Subject: P/159/21/PL

Please also note that application P/165/21/PL is the application for the actual access onto Spinnaker View whilst P/159/21/PL is just for changes to the Inglenook development layout. I see that you have separately responded to P/165/21/PL.

Drawing Title	Site Layout
---------------	-------------

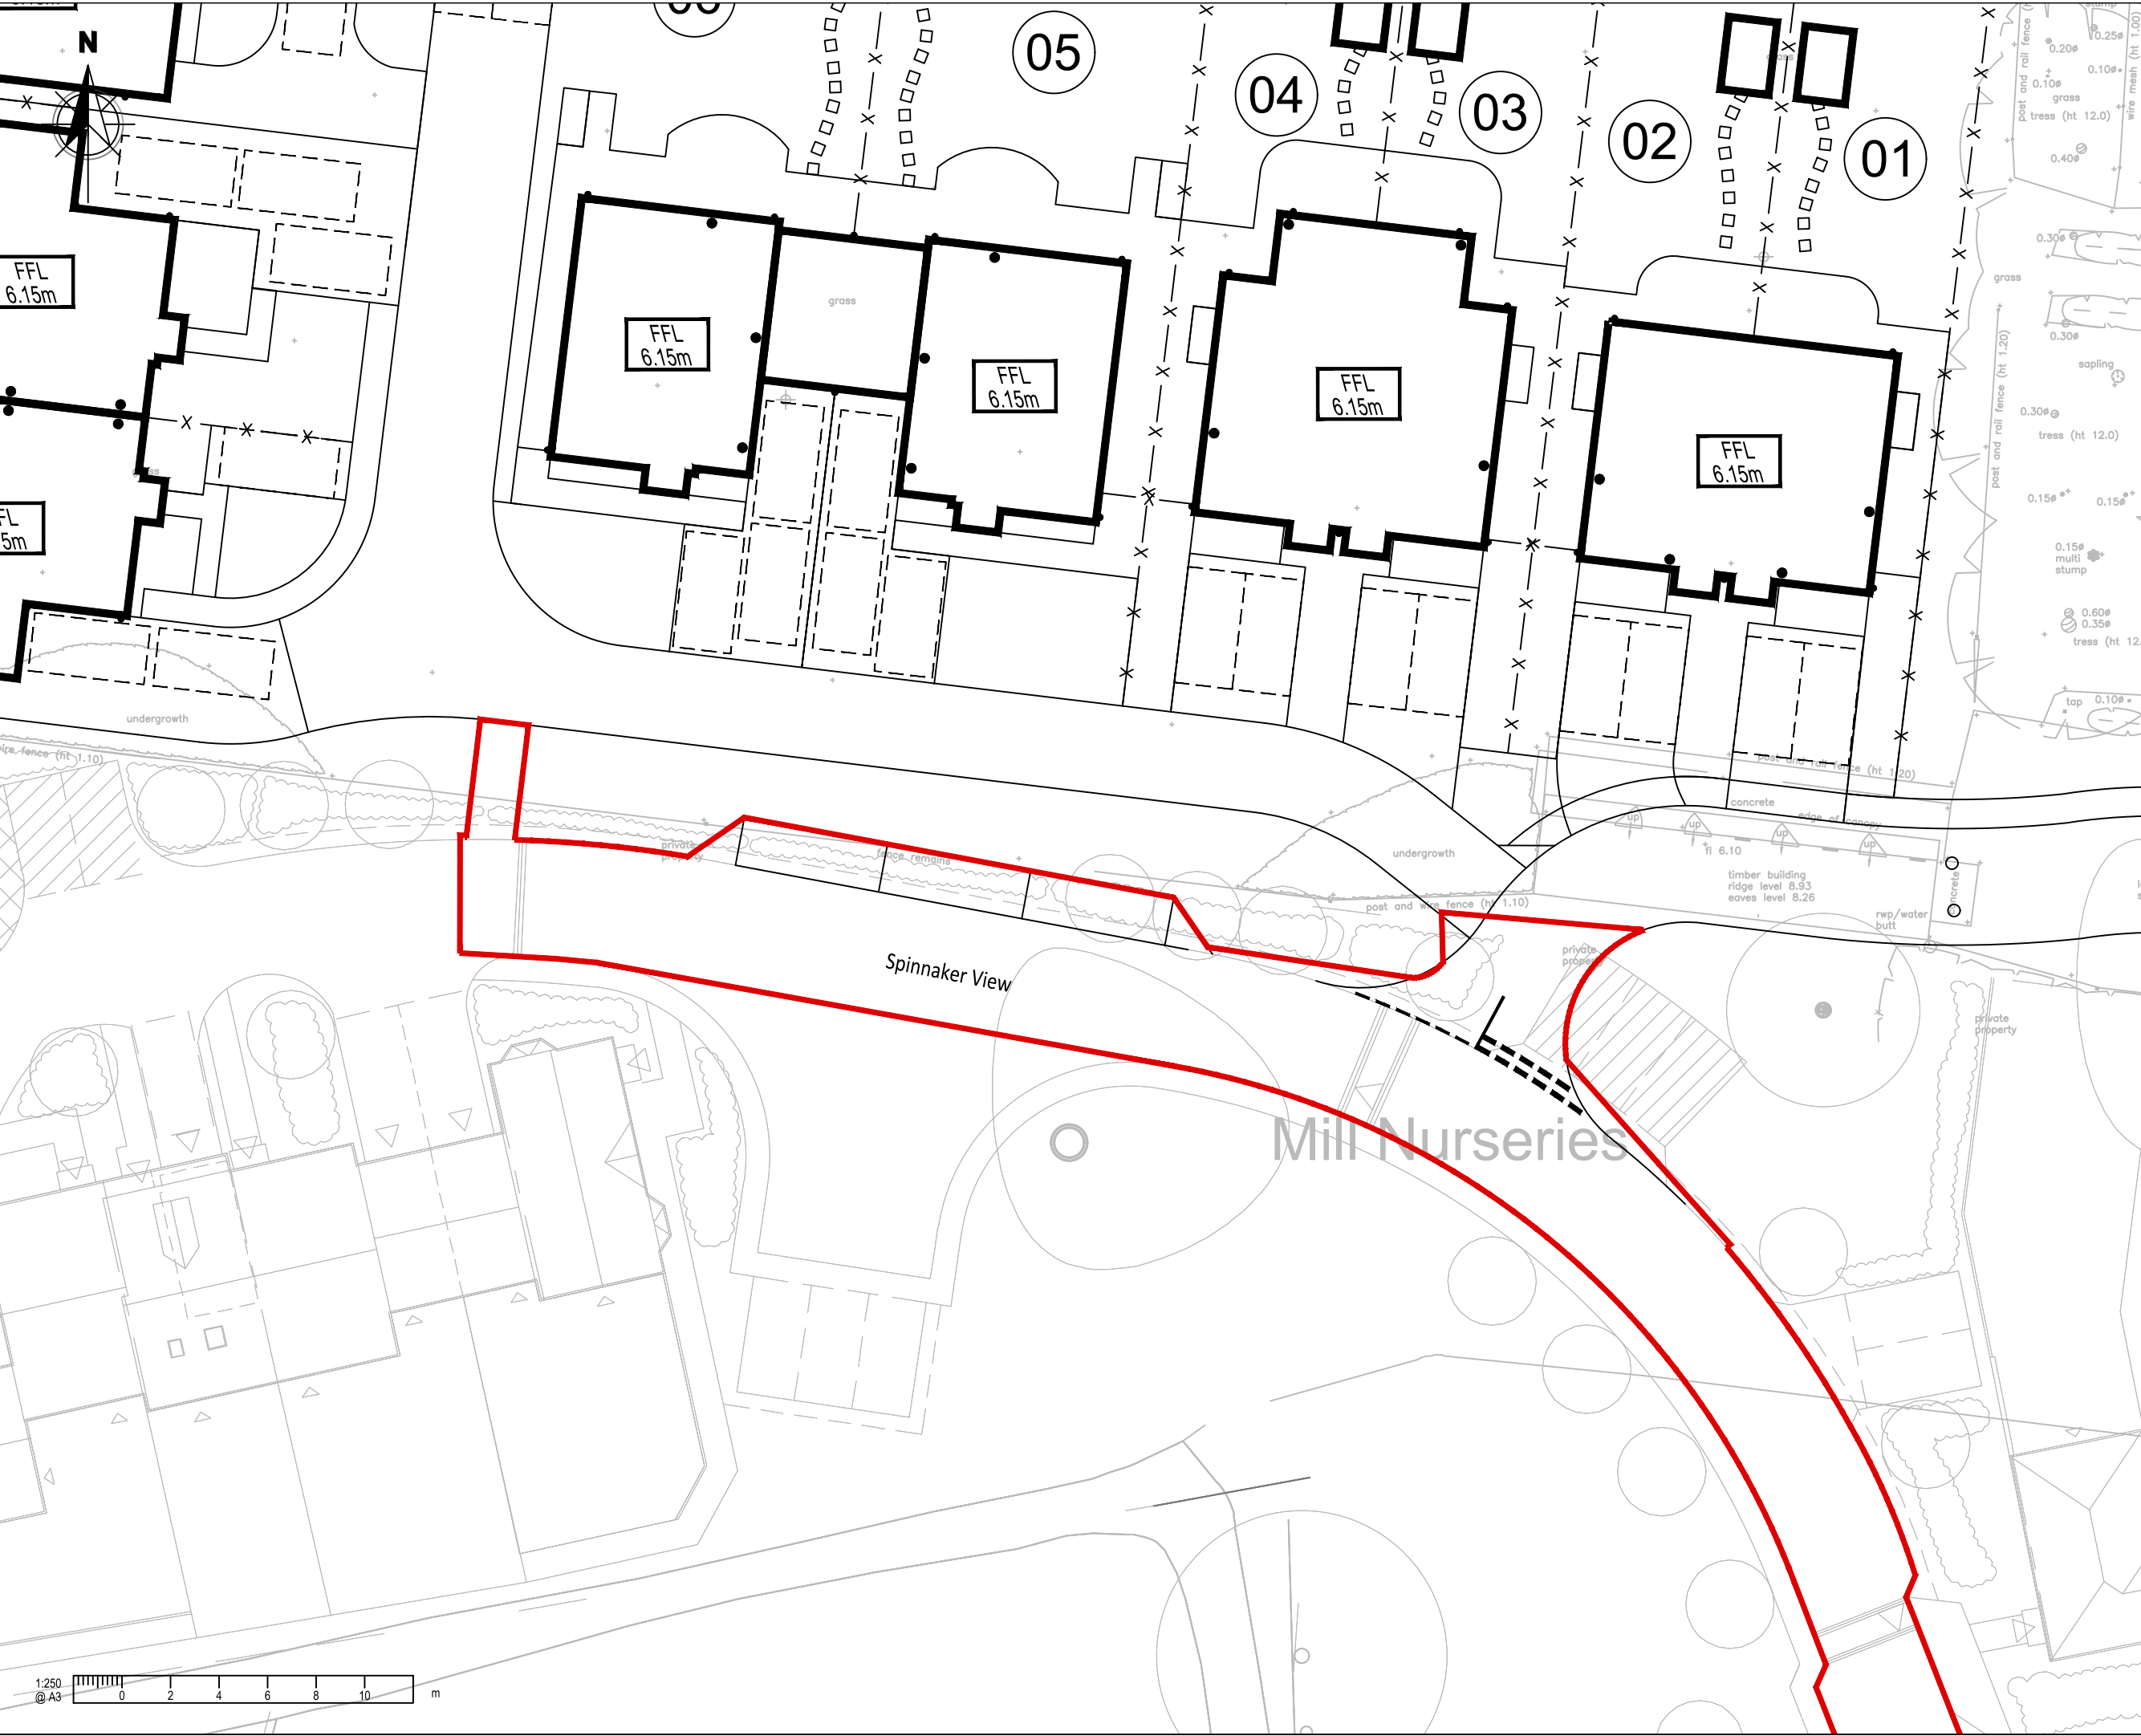
"In principle the parking arrangements are as previously approved under P/58/19. Some changes have been incorporated in the form of the removal of 3 visitor parking bays which have been provided as parallel parking to the west of the site."

Could you look at this again/revise your comments as they have added 4 extra parking spaces to the layout. This was at my request due to the extra demand created by the additional bedrooms in plots 5, 6, 8 & 9 (see my email attached explaining this).

This application is attracting a lot of objections (32 so far) and will be going to Cttee therefore it is vital that consultation responses are comprehensive and do not omit parts of the scheme. I have also seen a resident objection today stating *"Turning circle is not big enough as overhang of the Fire Tender swings over plot 6 land this is because plot 9 now have an additional parking space outside their garage. If plot 6 places hedges around its perimeter what happens? This is not a big enough turning circle and not fit for purpose. If this parking space is removed from plot 9 this wouldn't be suitable for a 4-bedroom house."*
